WELWYN HATFIELD COUNCIL – DEVELOPMENT CONTROL
DELEGATED REPORT

APPLICATION No:	S6/2010/0932/FP
------------------------	------------------------

PROPOSED FRONT ELEVATION

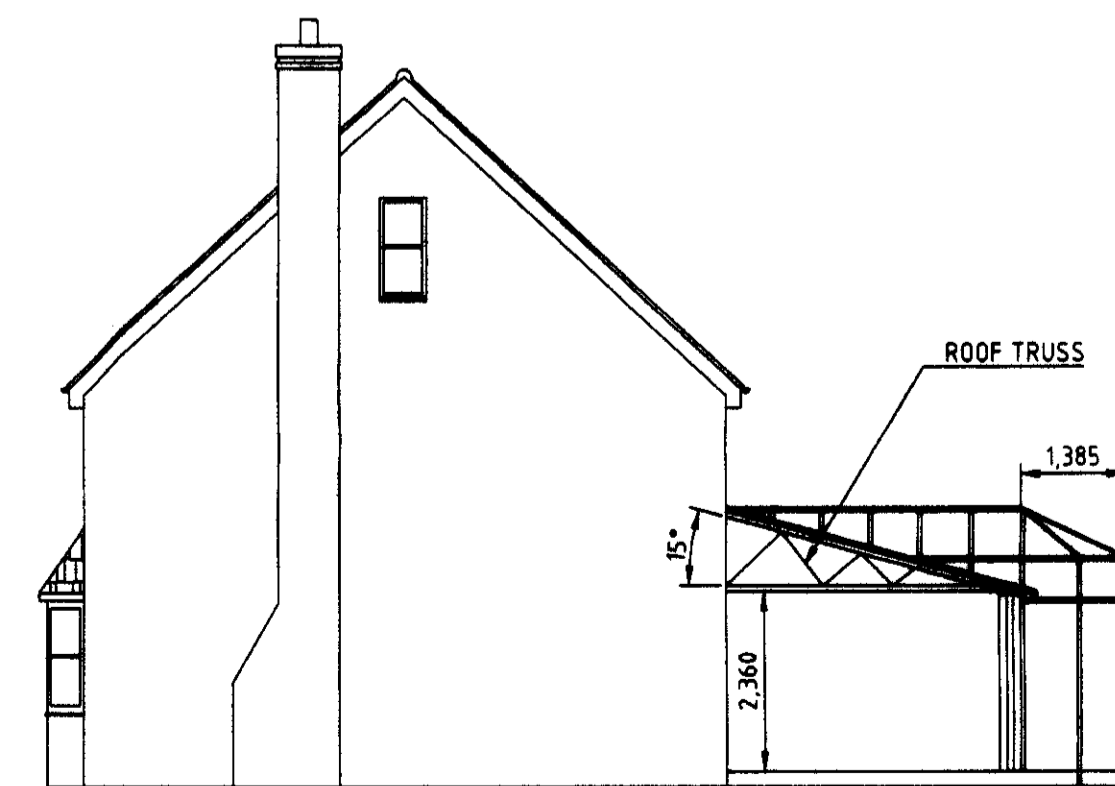
The proposed front porch is not considered to detrimentally alter the character of dwellinghouse by virtue of its minimal size and therefore complies with policy D1 and D2 of the Welwyn Hatfield District Plan, 2005.

To the front of the property, the proposed canopy porch measures 3.3 metres in height and 2.3 metres in width and includes the installation of two pillars.

PROPOSED REAR ELEVATION

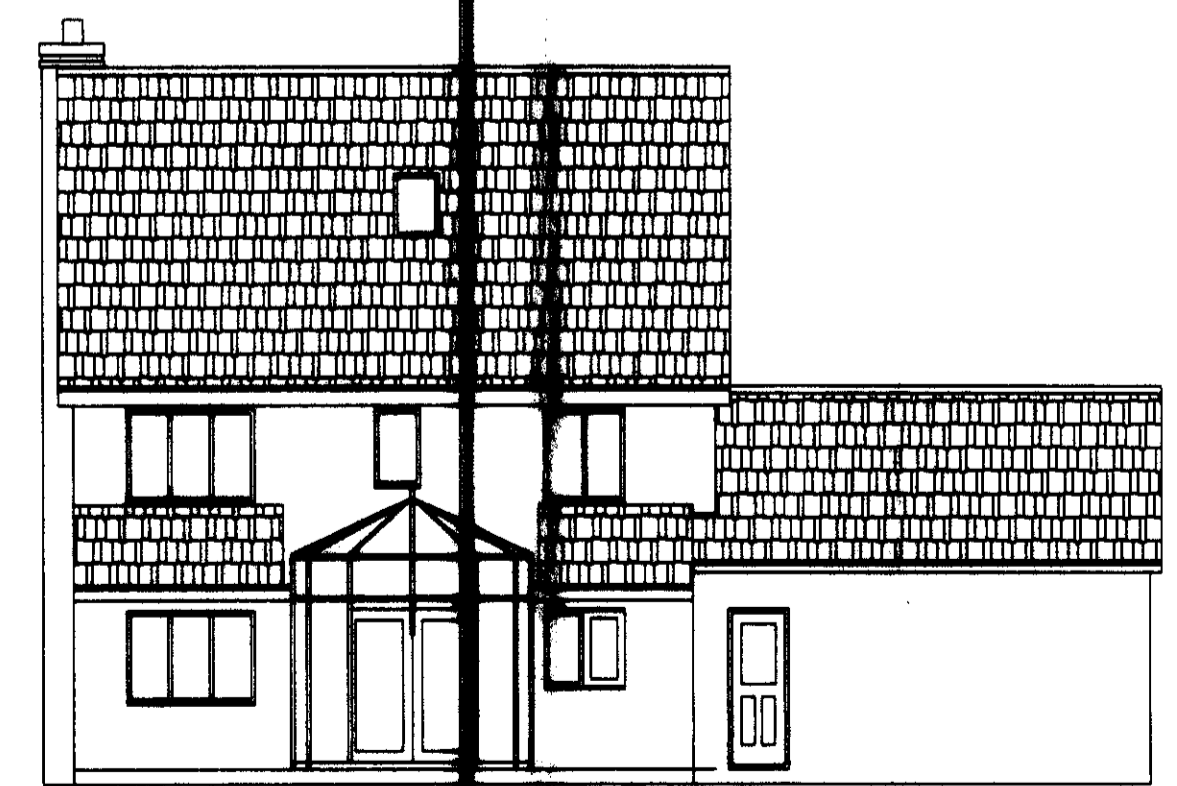
To the rear of the property, the proposal to create a single storey rear extension and conservatory is not considered to detract from the design and character of the dwellinghouse by virtue of its height and depth remaining subordinate to the existing dwellinghouse. In the original submitted plans the height of the proposed conservatory element of the rear extension measured 4.6 metres which was considered too high and would appear quite prominent when viewed from adjoining properties and in relation to the remaining proposed rear extension. In addition, it would not have appeared subordinate in scale to the existing dwellinghouse. The revised drawings show the height of the conservatory to be 3.7 metres which is a reduction of 0.9 metres. The revision to the height is considered to be more in

keeping with the height of the adjoining proposed rear extension and is not considered to appear overly dominant when viewed in relation to other single storey rear extensions and conservatories of neighbouring properties. The proposal therefore complies with policy D2 of the Welwyn Hatfield District Plan, 2005 by virtue of the conservatory and single storey rear extension maintaining the character of the existing area and policy D1 by virtue of the proposal remaining subordinate in scale to the existing dwellinghouse.

The revised proposal removes the playroom above the existing double garage. The application now comprises of the single storey rear extension which remains the same height as stated above. The conservatory element has been reduced in height by 0.9 metres and now measures 3.7 metres.
